8 February 2013
GMA Ref: 275/2008

**SUBMISSION IN RESPECT OF PROPOSED MODIFICATION OF STATE
SIGNIFICANT DEVELOPMENT
23-37 LINDFIELD AVENUE & 11 HAVILAH LANE, LINDFIELD
MP08_0244 – MOD 1**

2 WEST ELEVATION
SCALE 1 : 250

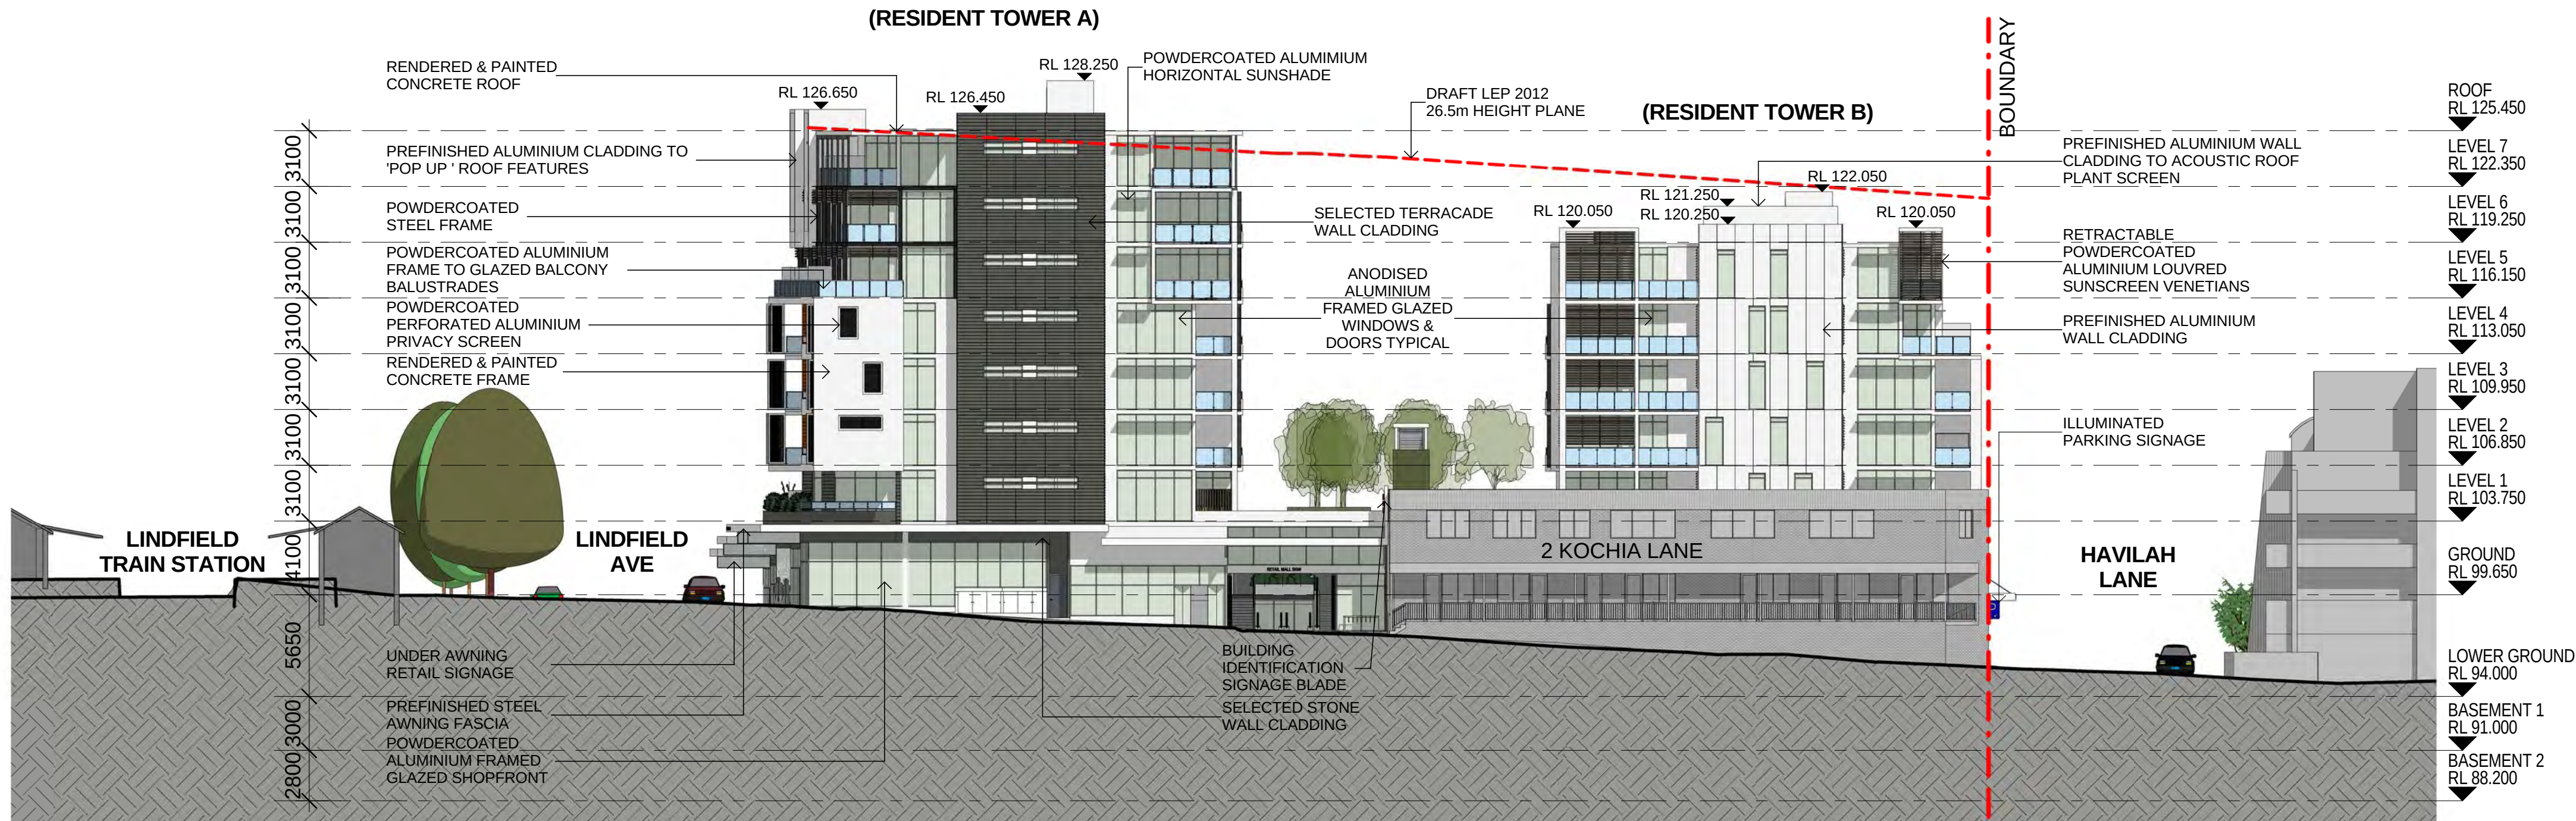
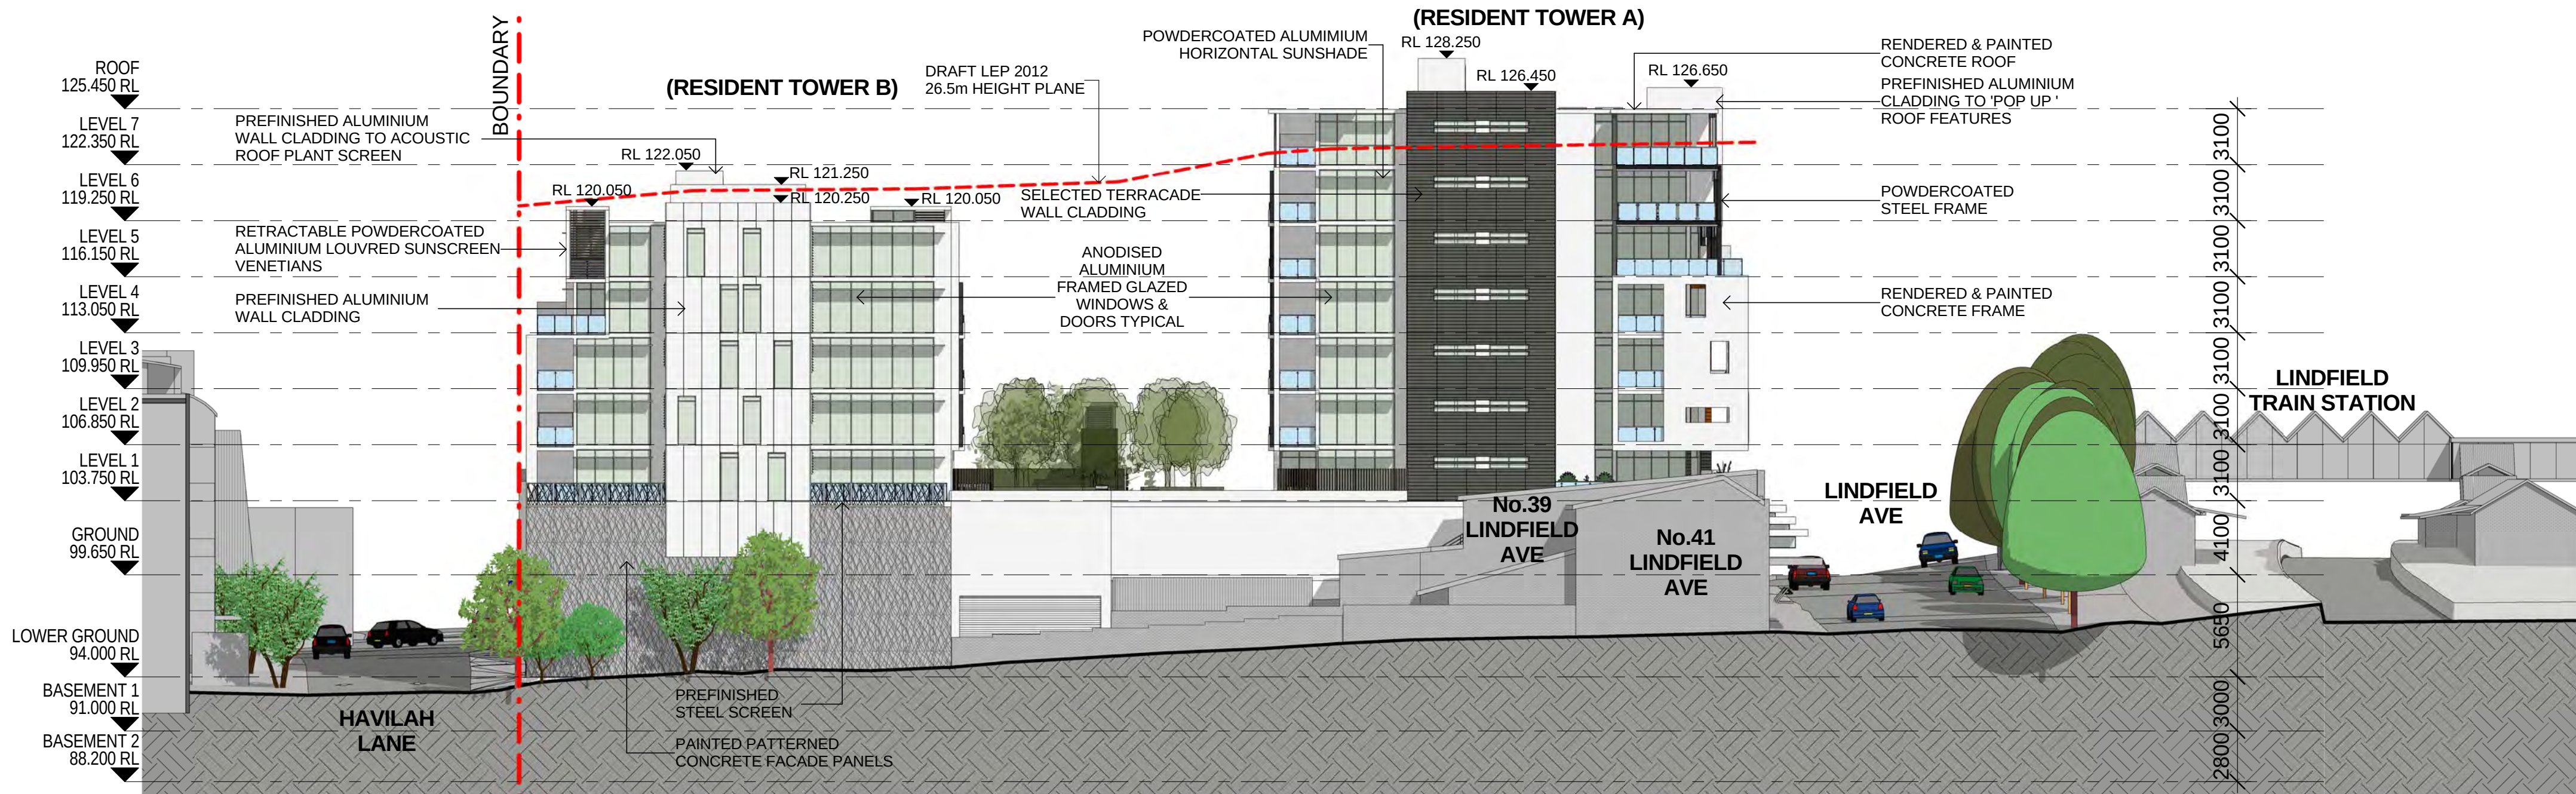
1. Location of Windows & Balconies in close proximity to the north western side boundaries of the site and the impacts of such an arrangement

- Windows to habitable rooms with a zero setback from the common boundary.
- Balconies with a zero setback to the common boundary
- Windows and balconies with setbacks of less than 3m from the common boundary and certainly less than 6m from the common boundary.

- (iii) Were the modifications to be approved the proposed building configuration would significantly limit the development potential of the adjoining properties and would not provide for the equitable development of those lands. In effect development upon the adjoining lands would be required to wholly accommodate all required building setbacks (required in order to satisfy both the Building Code of Australia & SEPP No.65) upon their lands. In some circumstances this could require a 12m setback be provided upon the adjoining sites which could in effect prevent the reasonable development of those lands.

It is therefore submitted that the relationship of the proposed development to the north-western common boundary with the subject properties will result in unreasonable impacts upon the future development of those lands and should not be supported.

To this end it is requested that the applicant be required to demonstrate how the adjoining sites can be developed to their maximum potential having regard to the constraints and imposition caused by the inadequate and inappropriate setbacks which are proposed.

1 HAVILAH LA ELEVATION
2001 SCALE1 : 250

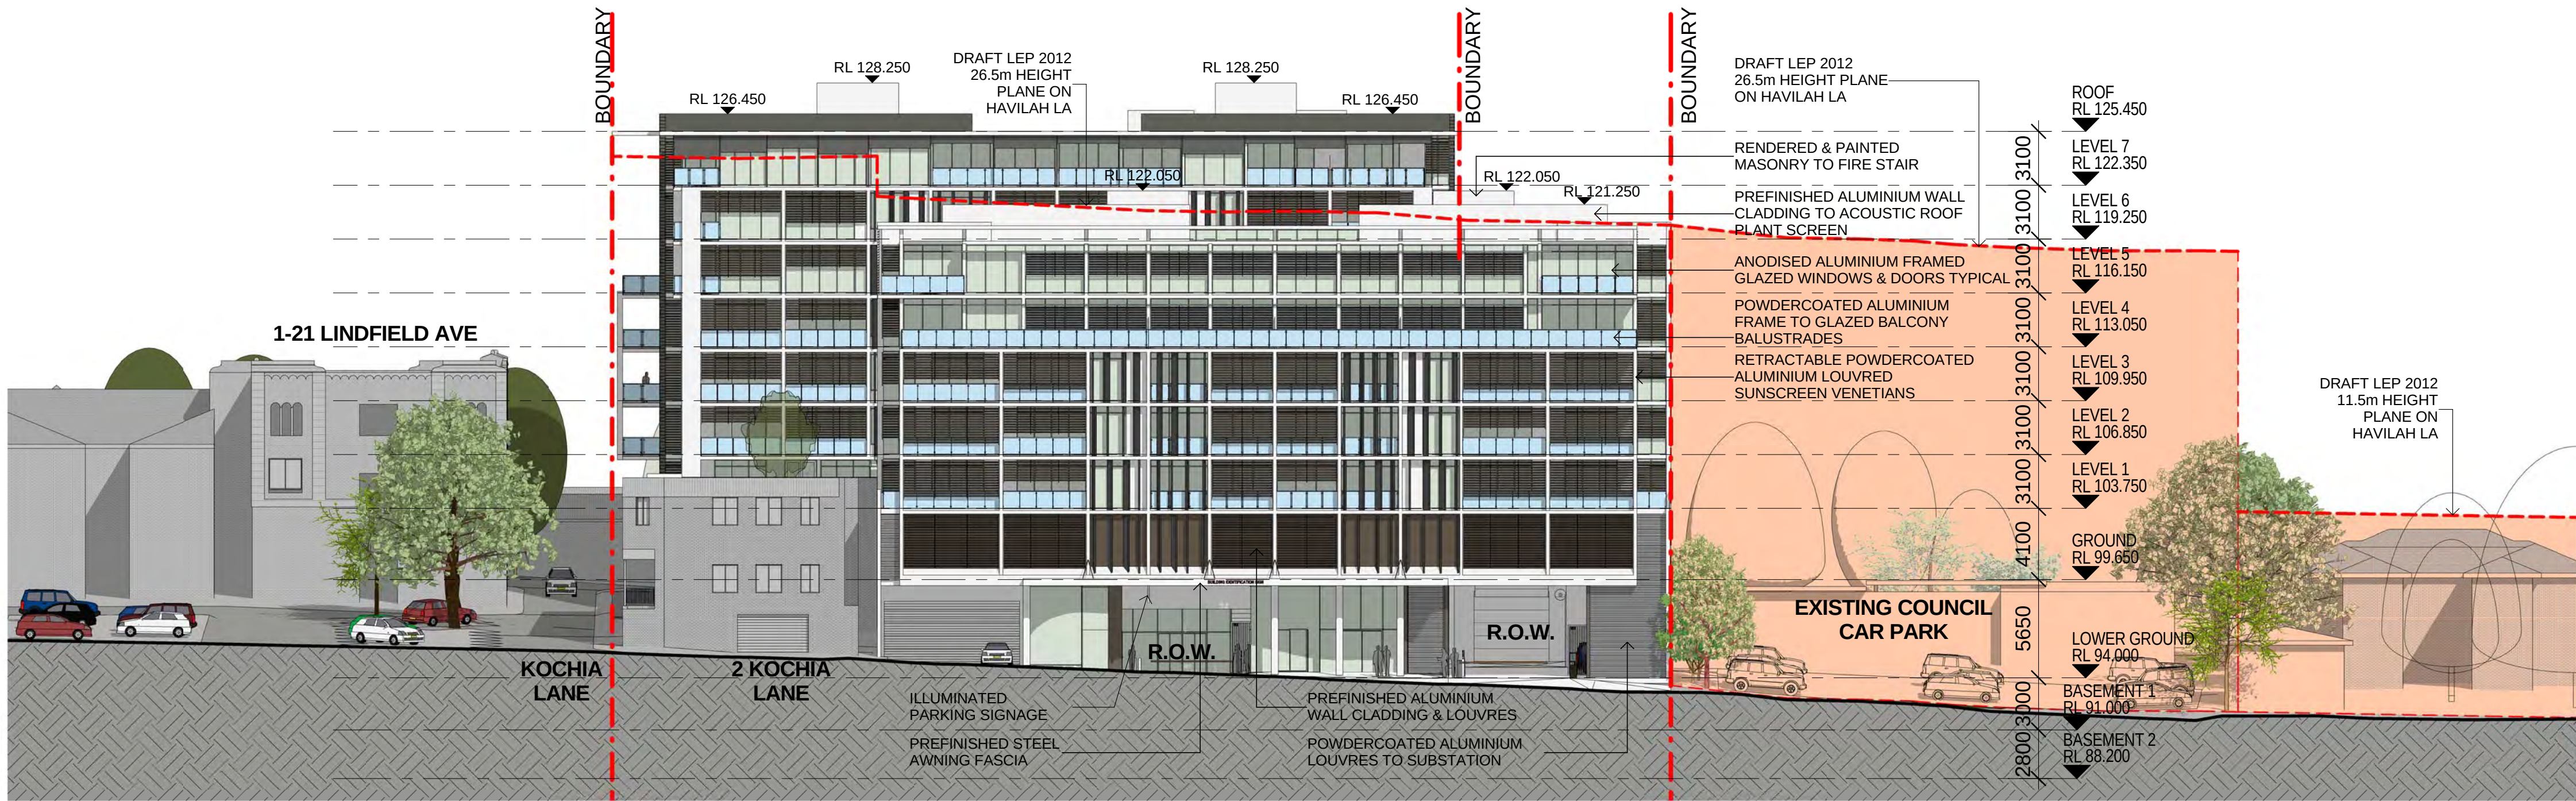
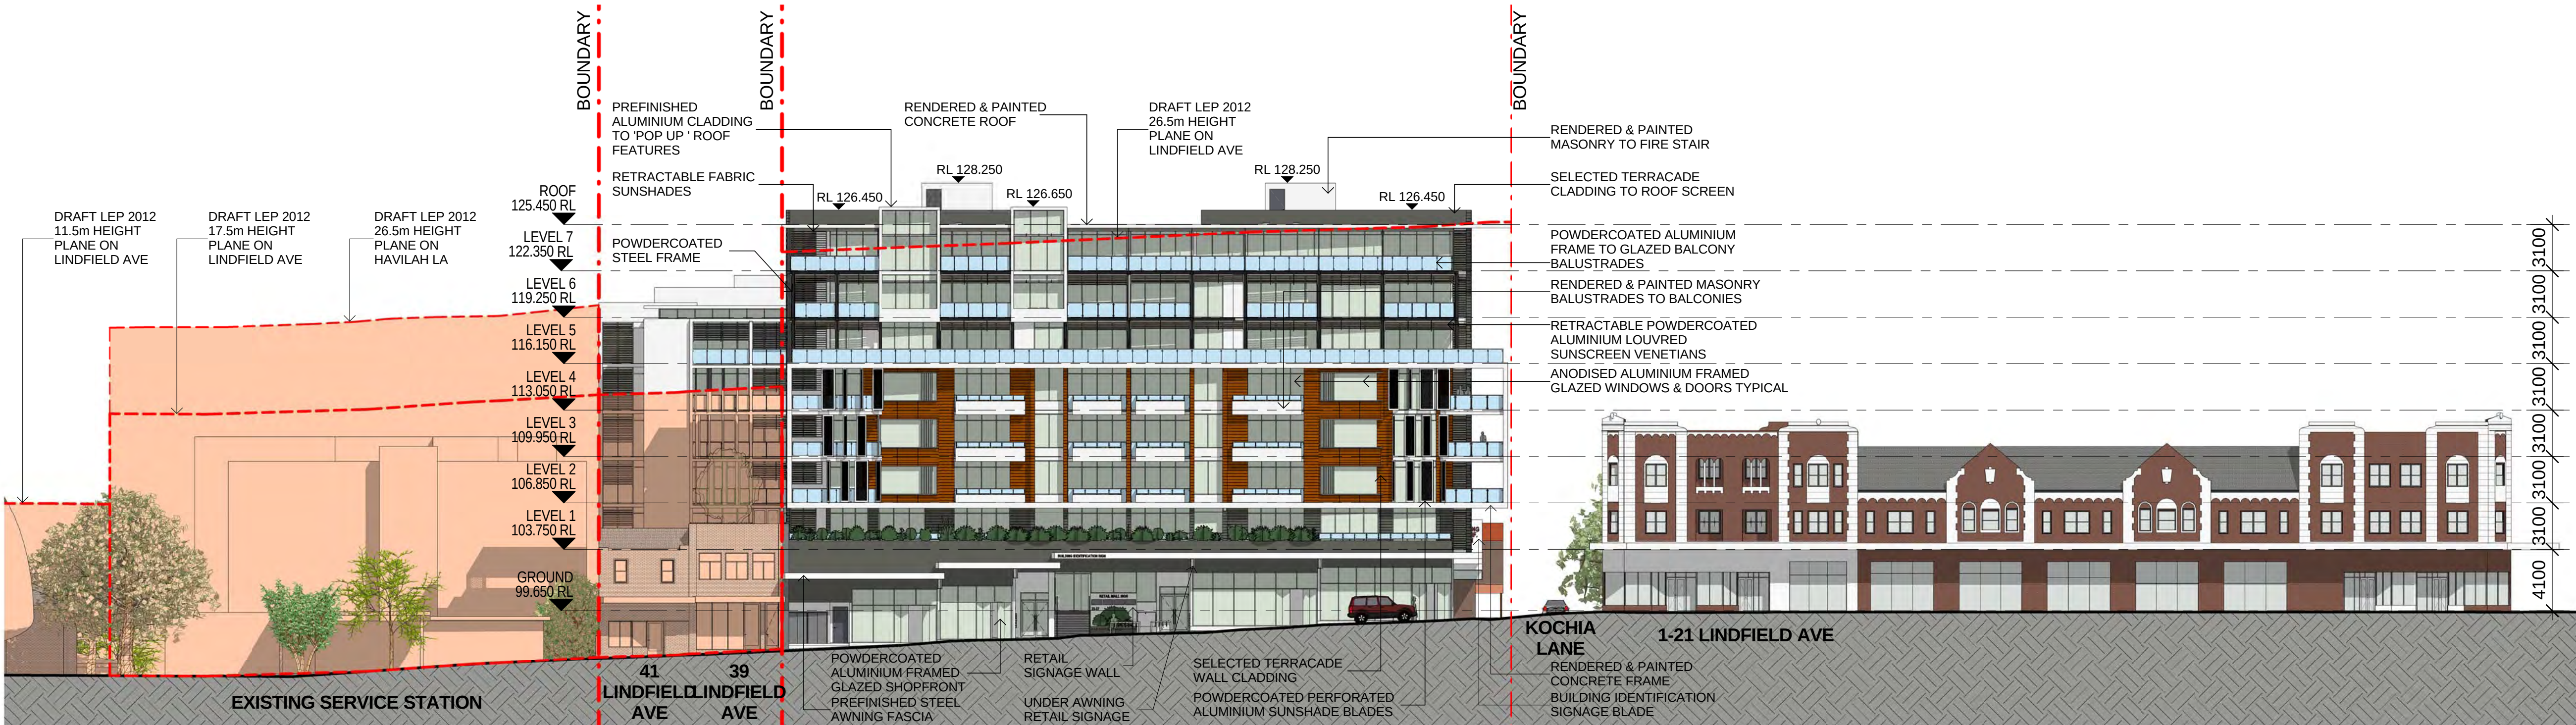
It is noted that the proposal provides for an increase in building heights of 4.28m in the case of Building A and 4.52m in the case of Building B.

In both cases the increase in the proposed building heights will provide for non-compliances with the Height Controls contained within the now adopted Ku-ring-gai Local Environmental Plan (Local Centres) 2012.

It is submitted that the proposal should be required to achieve compliance with the height controls required to be complied with by the adjoining sites.
